## **Peartree Hill Solar Farm**

# **Environmental Statement Addendum**

Application Document Ref: EN010157/APP/8.2

July 2025

Figure 11.8: Solar PV Modules Year 10 Post Mitigation ZTV

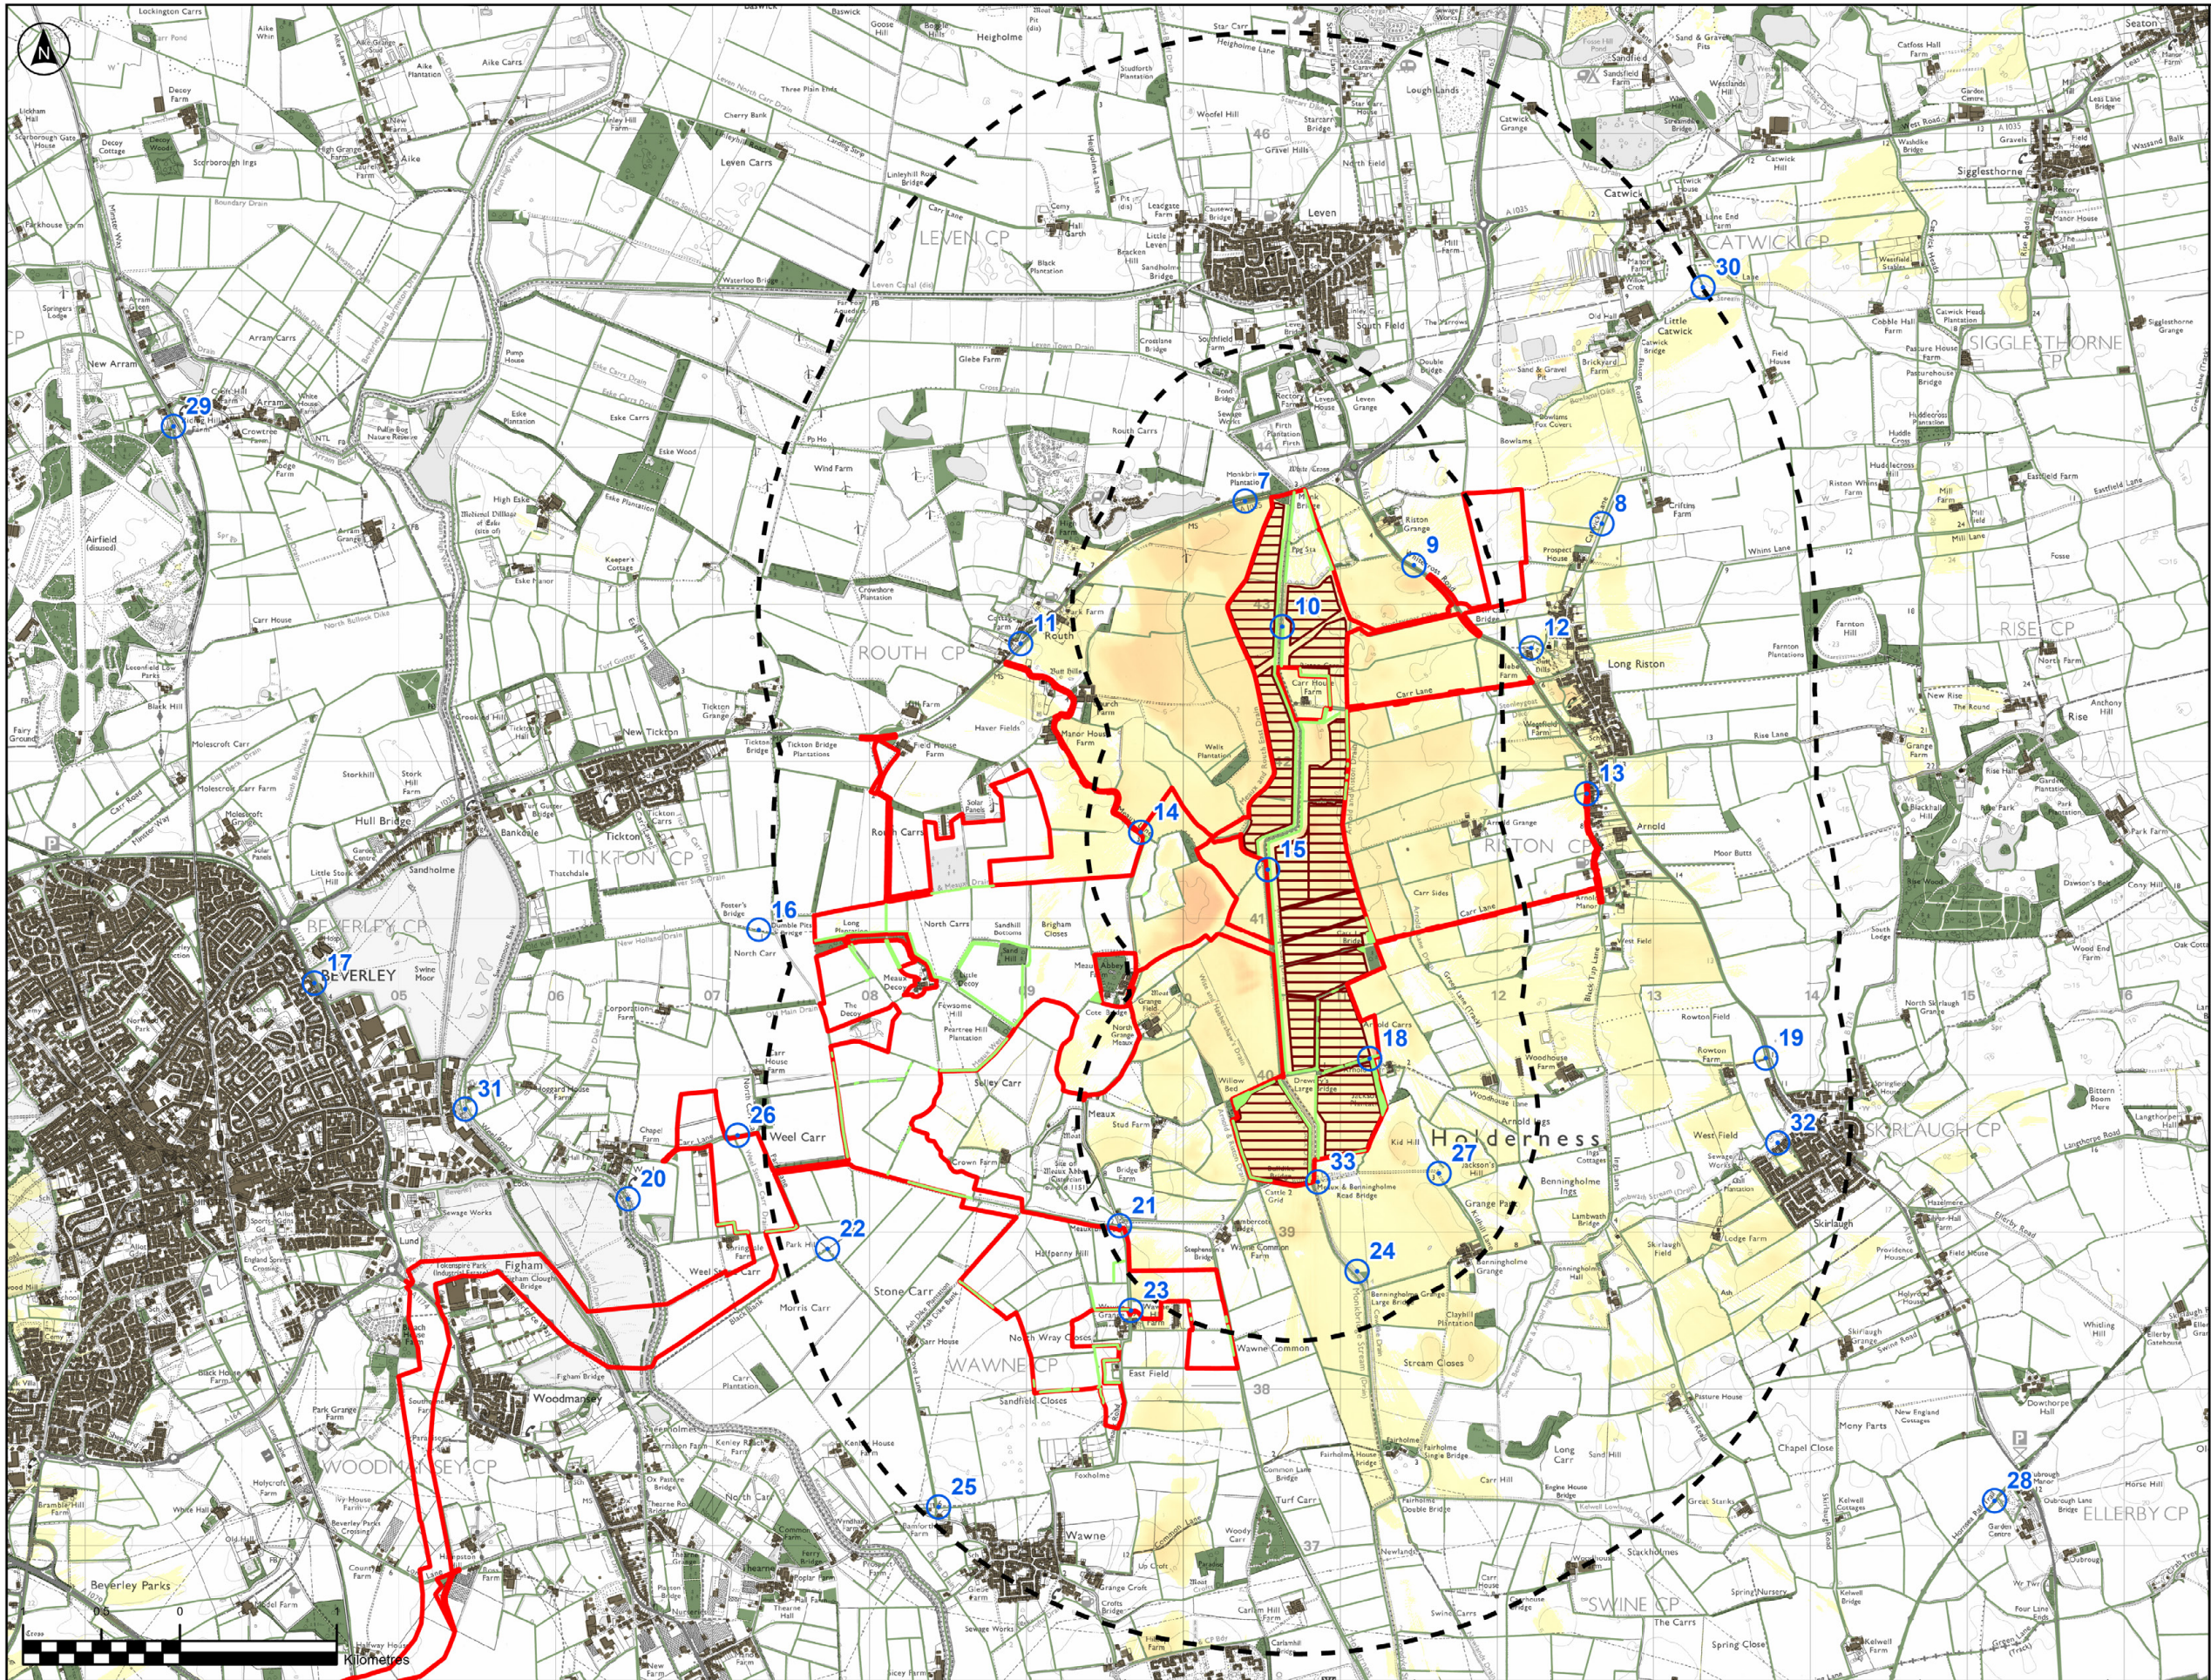
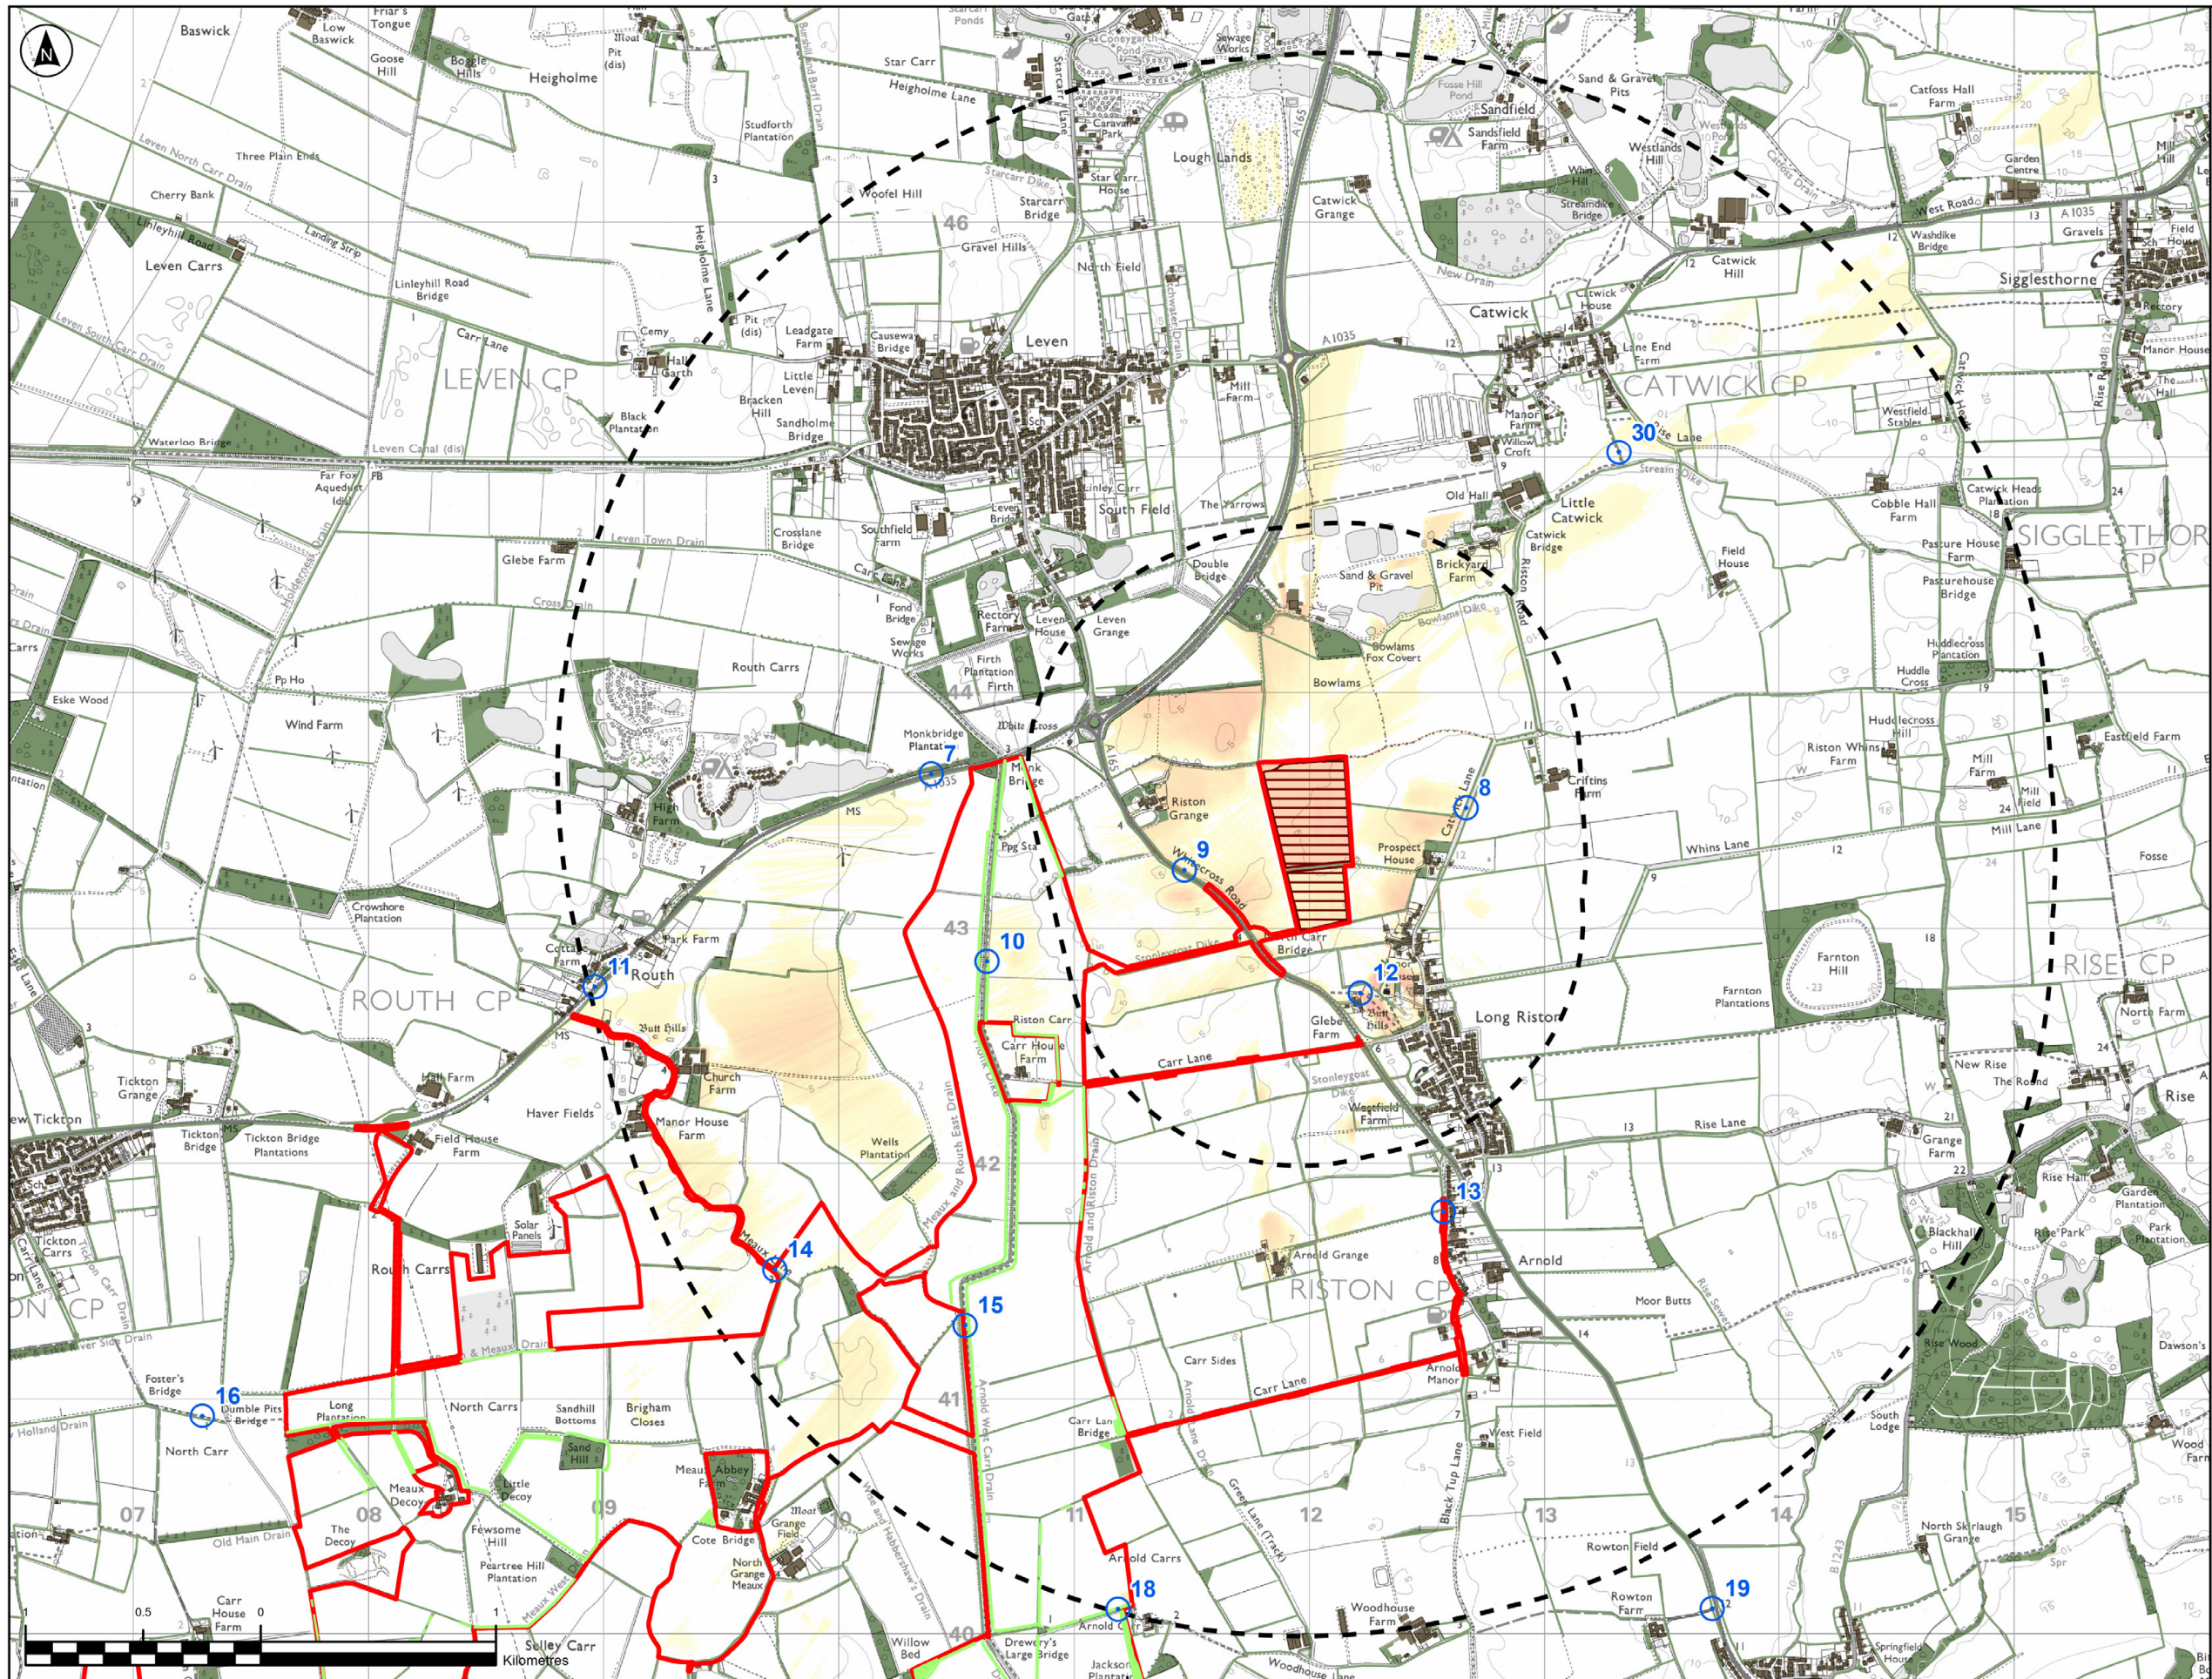
ES Volume 3, Figure 11.8: Solar PV Modules Year 10 Post Mitigation ZTV [APP-079]	<p>Figure 11.8 requires amendment to reflect the removal of a section of solar array from Land Area B as part of change/correction 1.</p> <p>Figure 11.8 also requires amendment to reflect the removal of plots 10-4, 10-5 and 10-6 as part of change/correction 2.</p>	
ES Volume 3, Figure 12.1: Study Area for Noise – Construction and Decommissioning [APP-080]	Figure 12.1 requires amendment to reflect the removal of plots 10-4, 10-5 and 10-6 as part of change/correction 2.	
ES Volume 3, Figure 12.2: Study Area for Noise – Operation (including Maintenance) [APP-081]	Figure 12.2 requires amendment to reflect the removal of plots 10-4, 10-5 and 10-6 as part of change/correction 2.	
ES Volume 3, Figure 12.3: Baseline Noise Monitoring Locations [APP-082]	Figure 12.3 requires amendment to reflect the removal of plots 10-4, 10-5 and 10-6 as part of change/correction 2.
